Town & Country Planning Act 1990 (as amended)
Town & country Planning (Development Management Procedure) (England) Order 2015
Application for Planning Permission for Works or Extension to a Dwelling

Development Single storey rear extension, single storey front/side infill extension & removal of entrance porch at front.

Location 98 Elmer Road Middleton on Sea

Block Plan Amend

Front Elevation ~ As Proposed

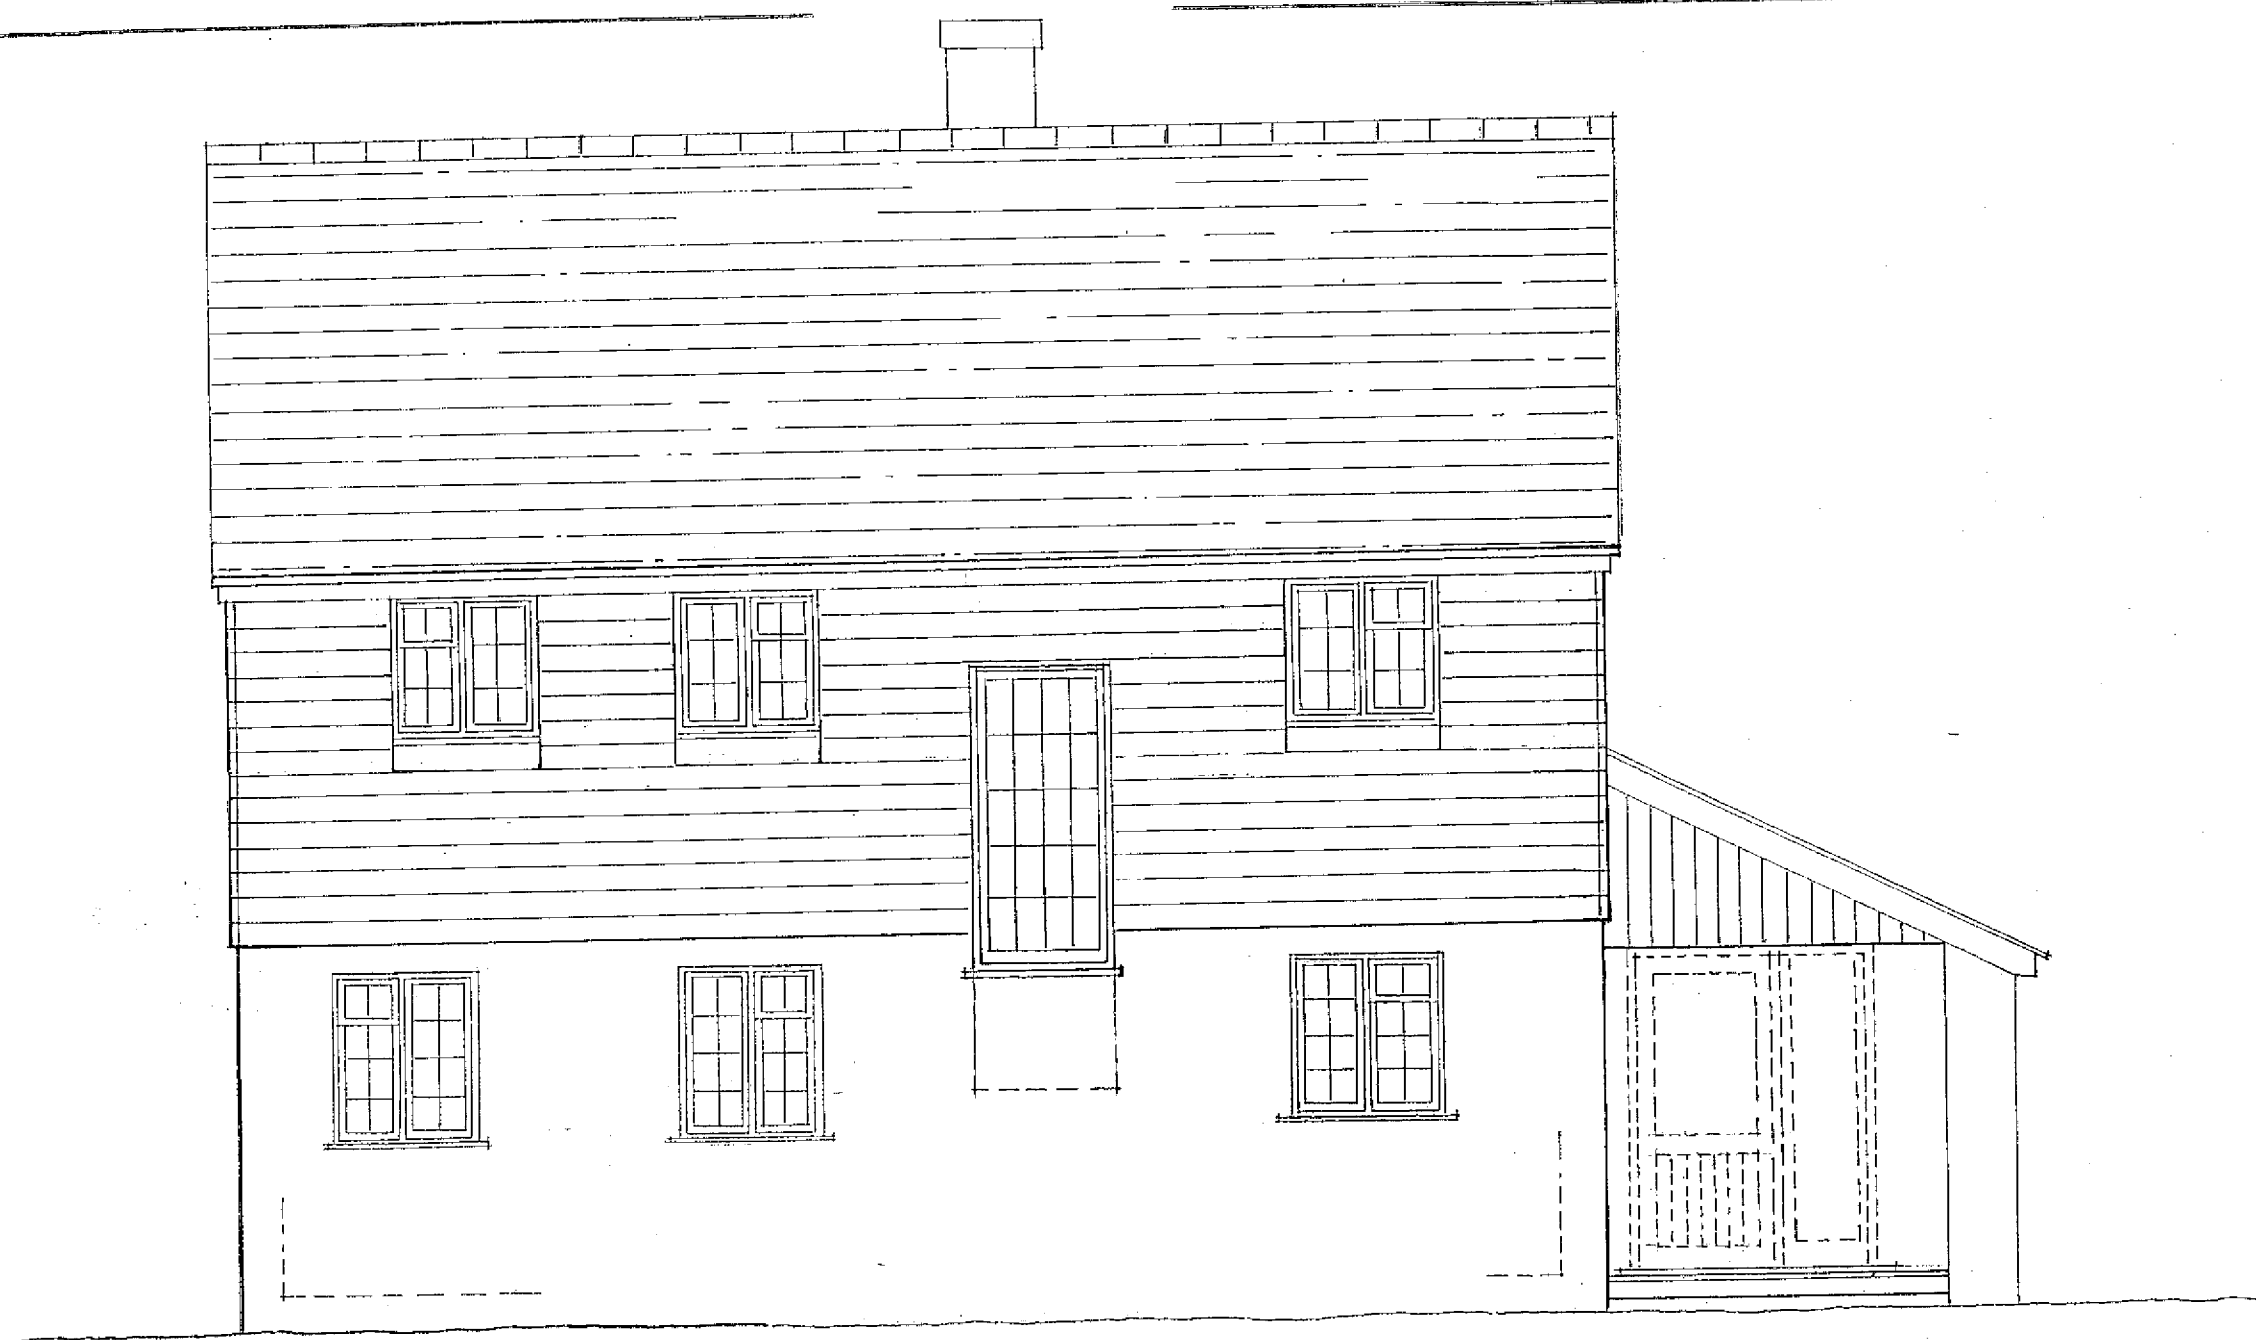
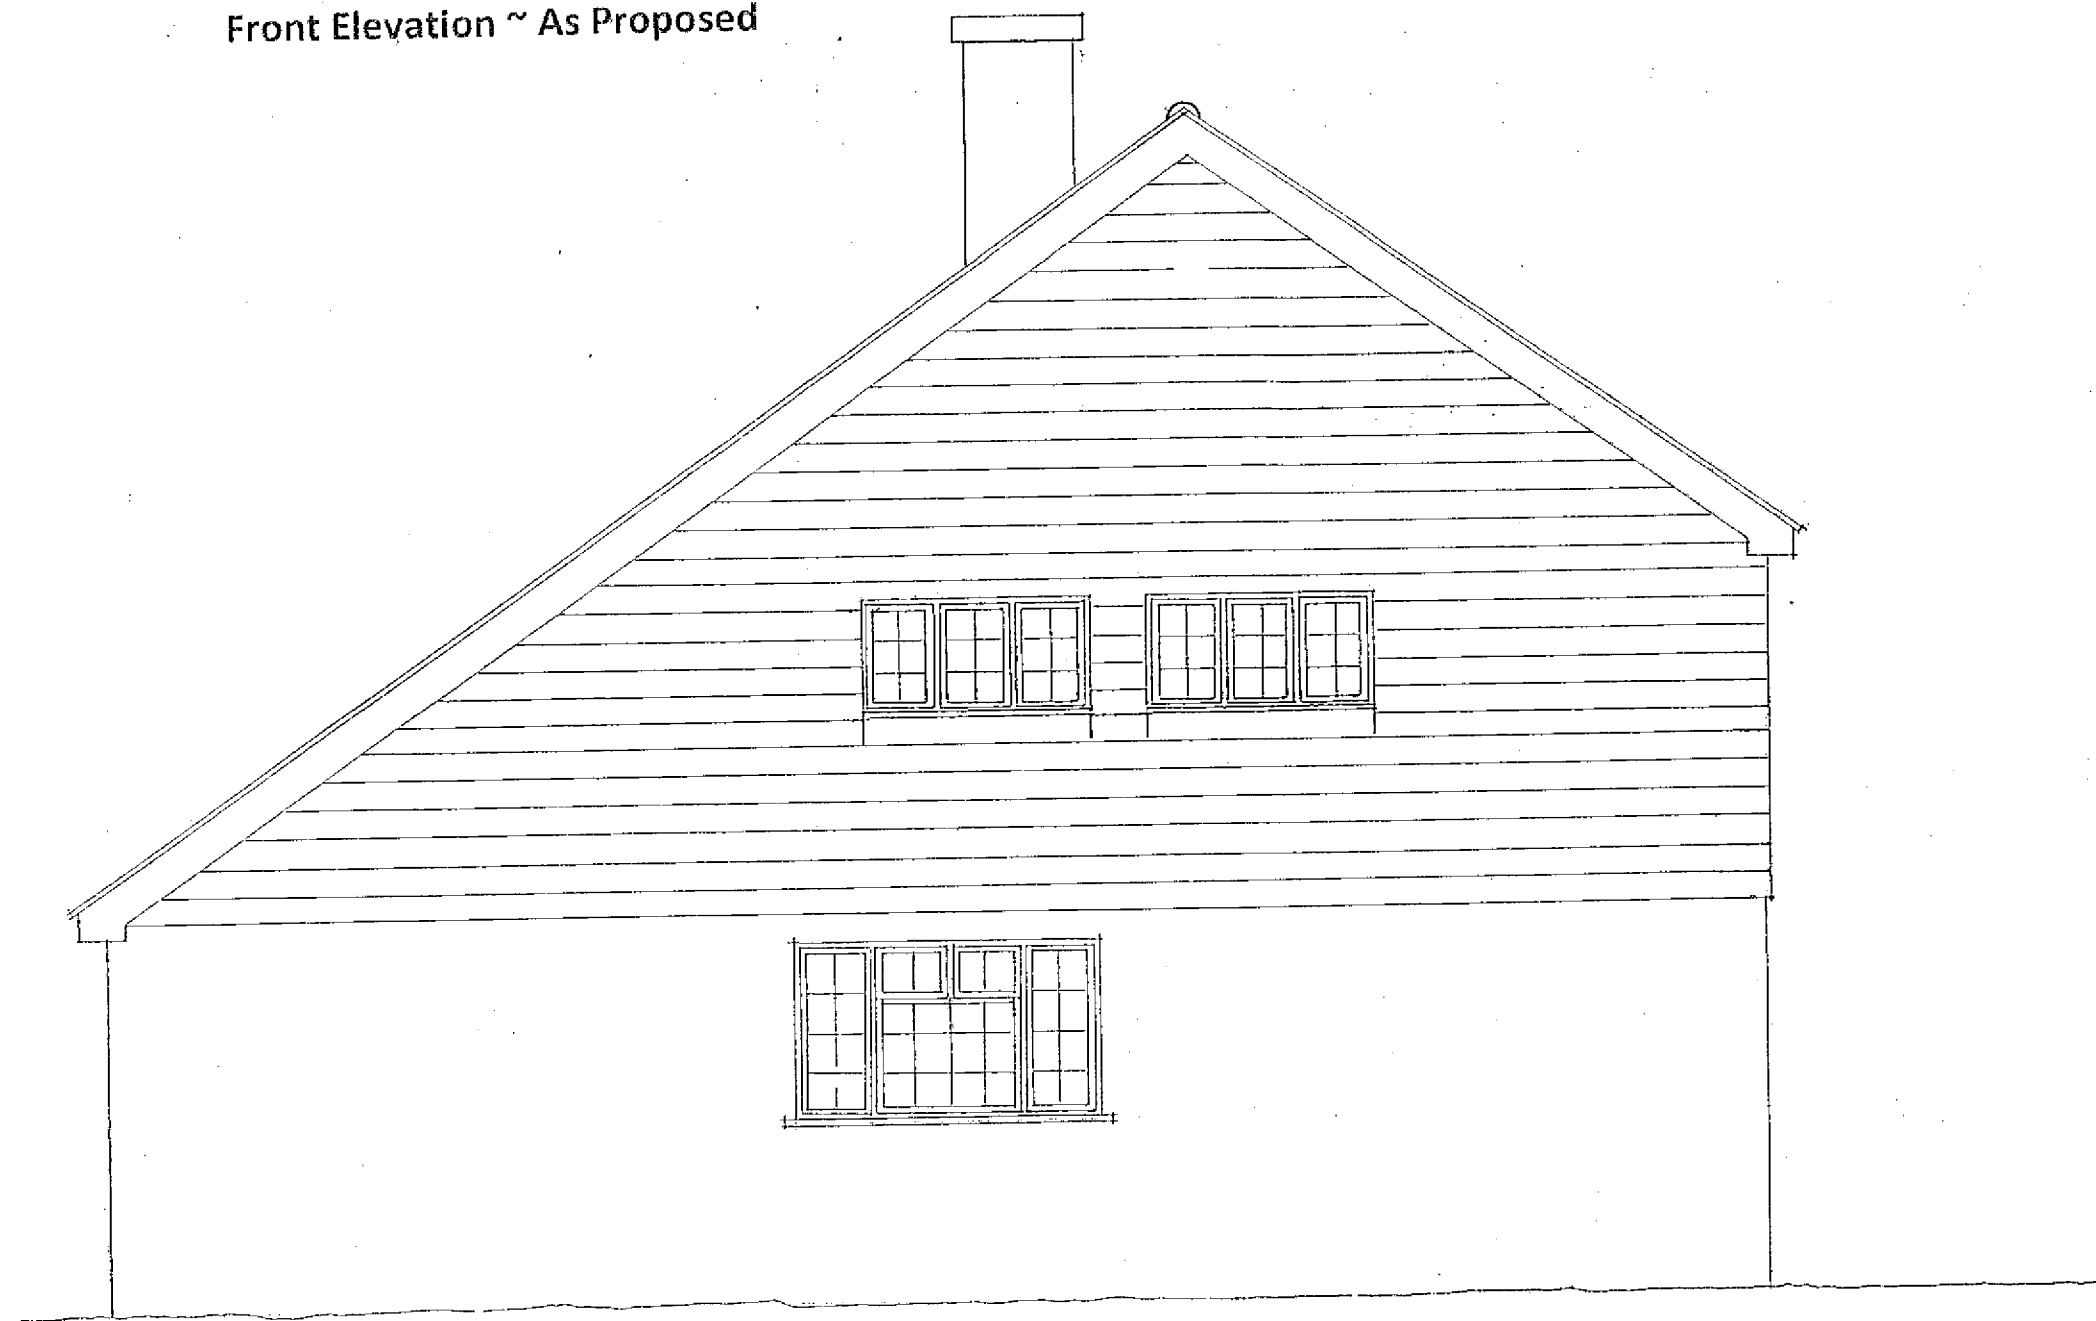
The proposed front ground/first floor plan and front elevation do not accord. Please amend accordingly.

Please confirm if you wish for the proposed cladding at first floor level should be included in the application description. Also please confirm that the amended description is satisfactory
